PLANNING AMENDMENT

H08/1404/02/A1

TWO STOREY EXTENSION TO DWELLING HOUSE

**Proposed alterations and extension to The Firs, Siltside,
Gosberton Risegate for Mr & Mrs D Matthews
Planning Permission Ref: H08/1404/02
Listed Building Consent: H08/1405/02**

Drawing Number: A0026 - 04 Rev: A

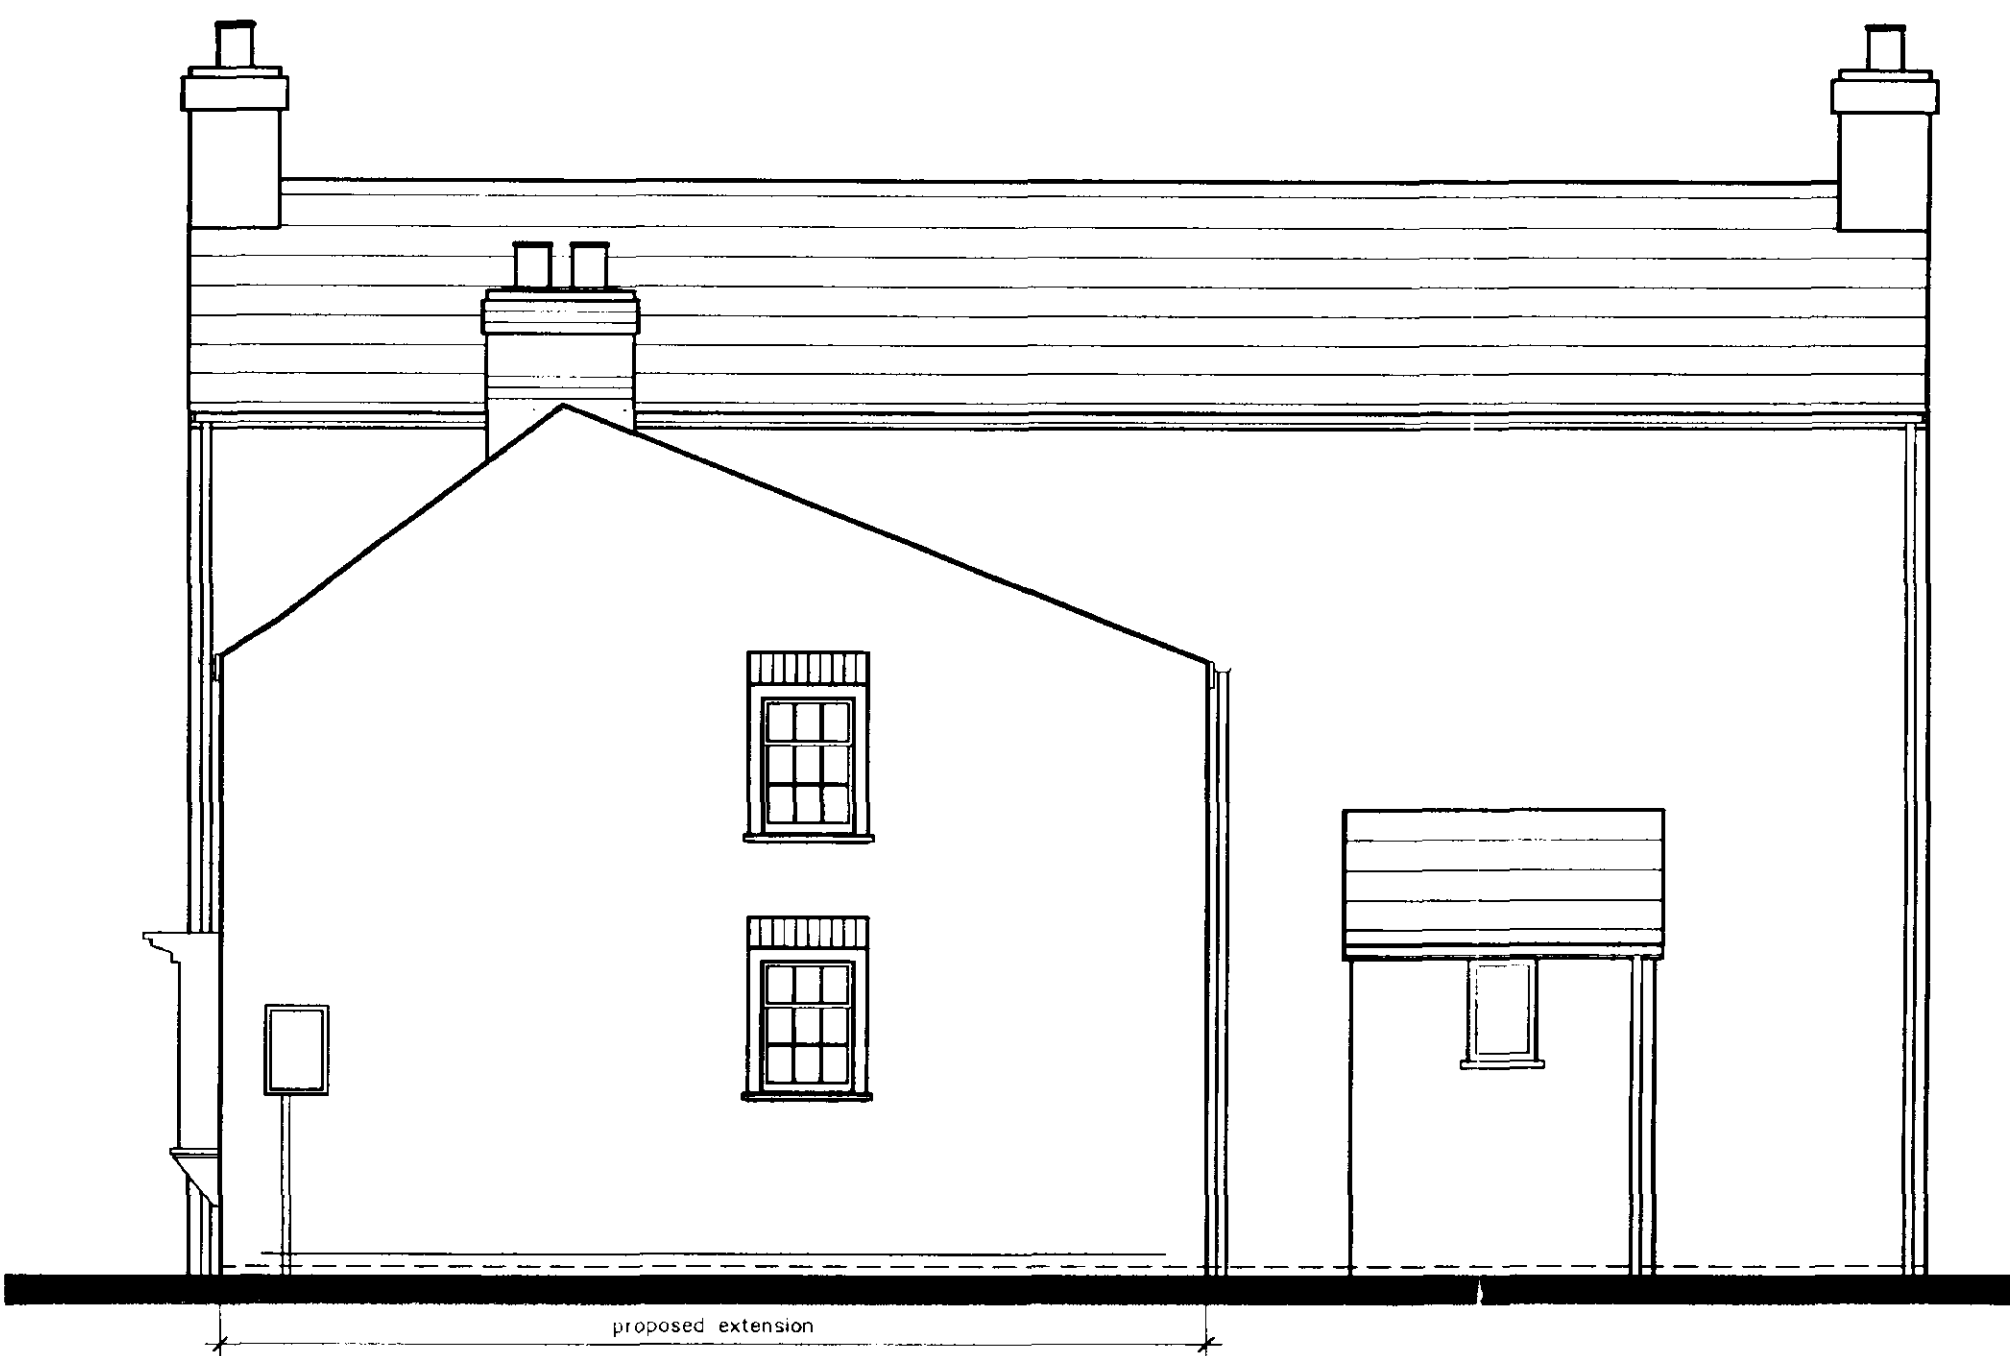
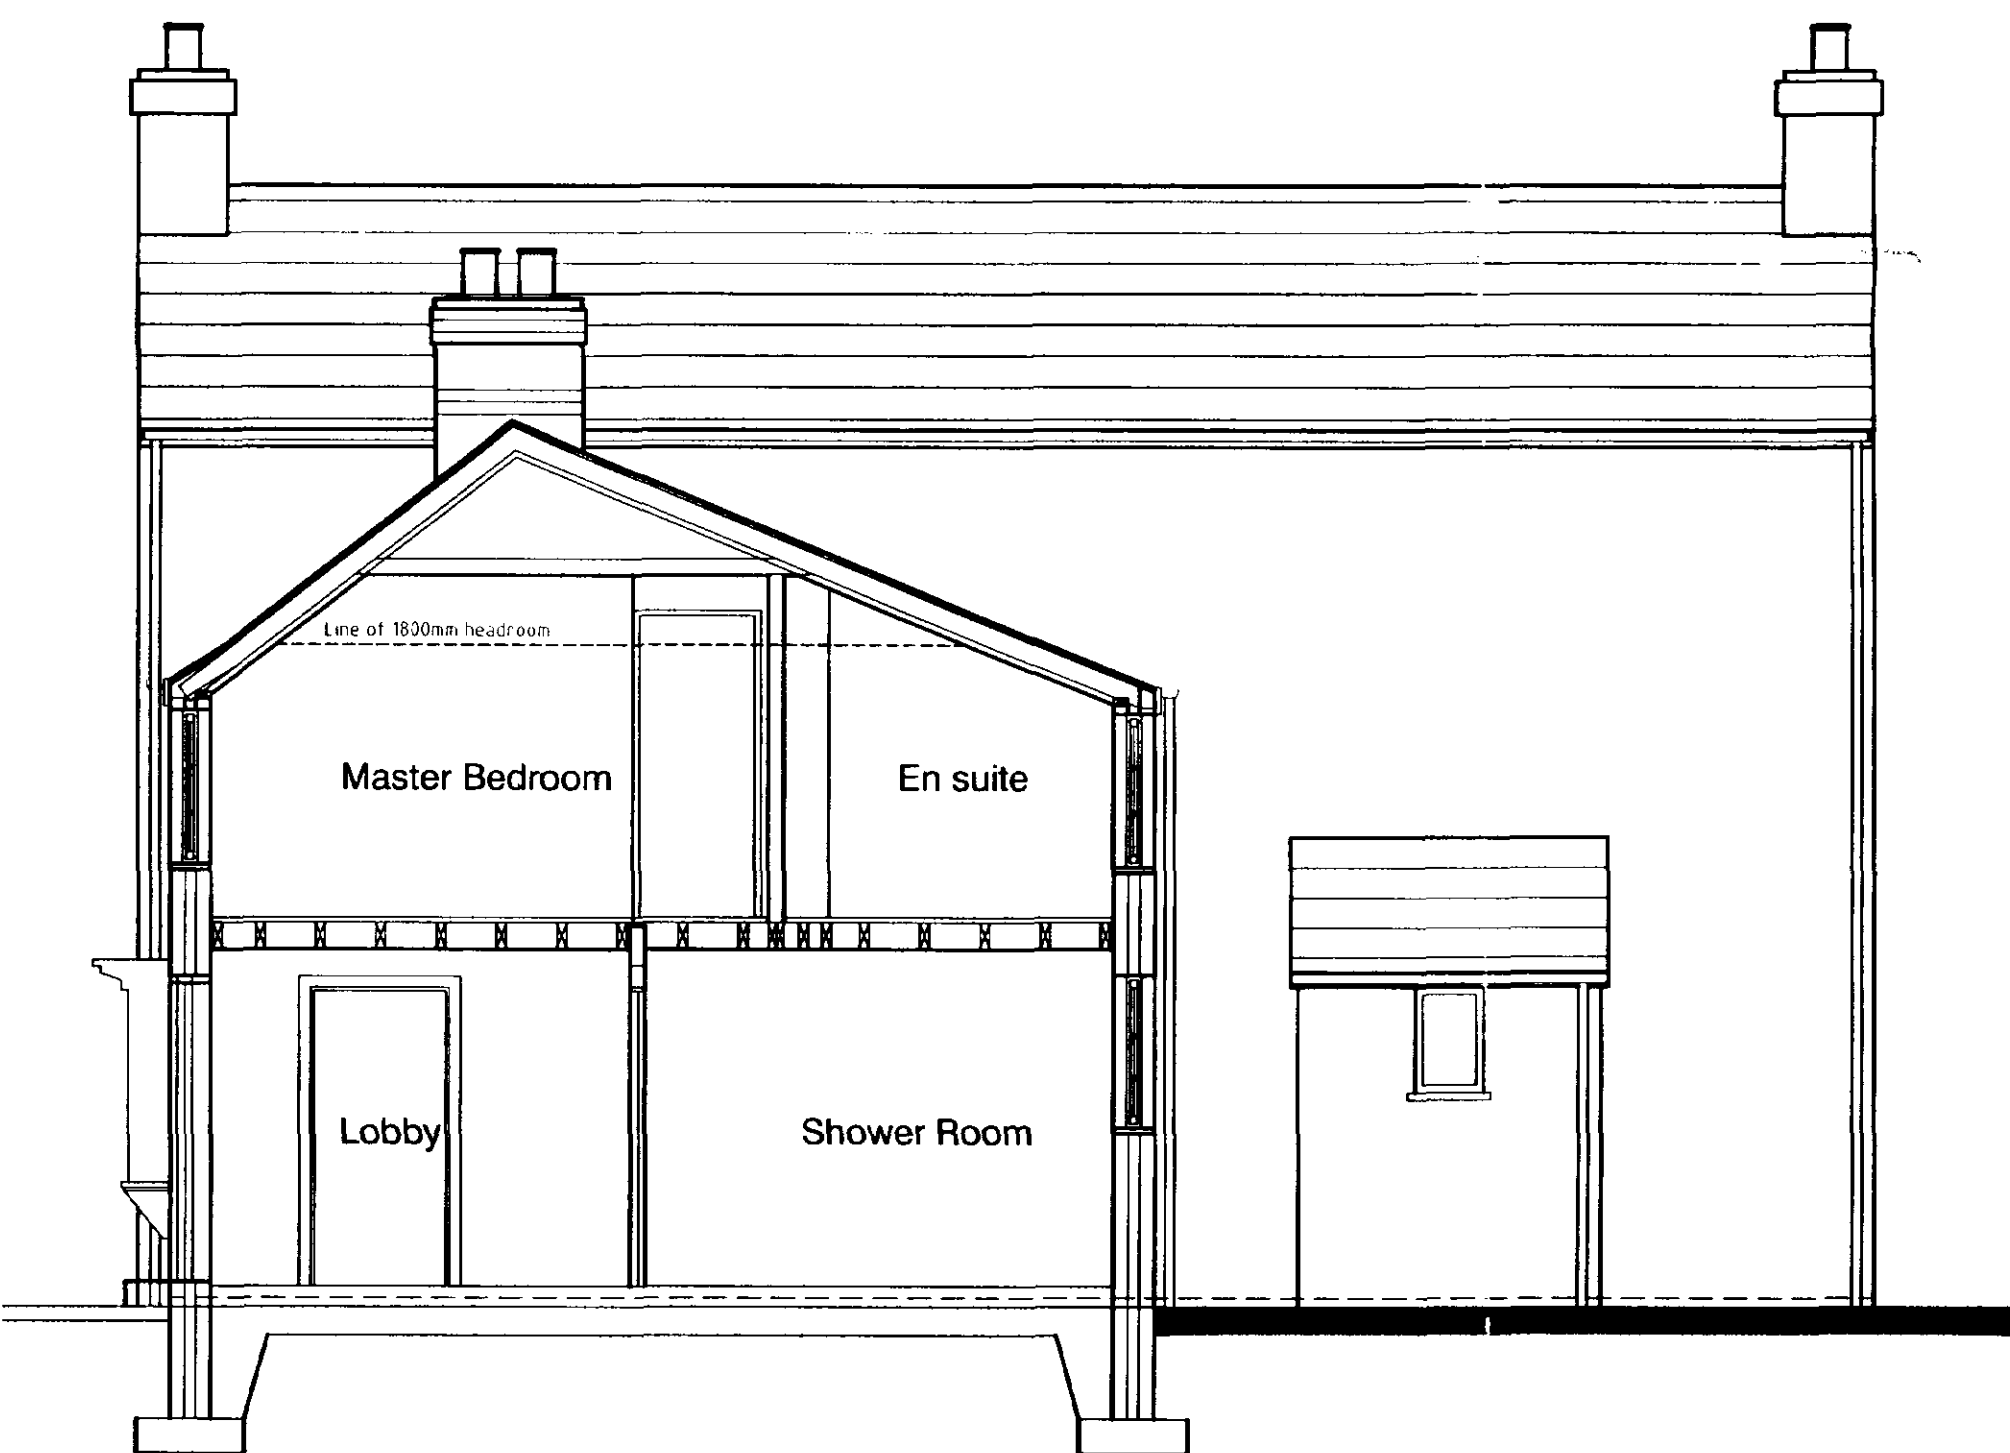
REDUCTION IN EXTENSION SIZE

Amendment: Reduction in extension size
Dwg. nos. A0026-03A & A0026-04A

With reference to the above project for which consent was granted in February of this year we now enclose a copy of the scheme drawings revised to take into account the reduction in extension size required by our client.

The amended details submitted in respect of the above proposal have now been considered and there are no objections to the amendment being implemented to the extent described above.
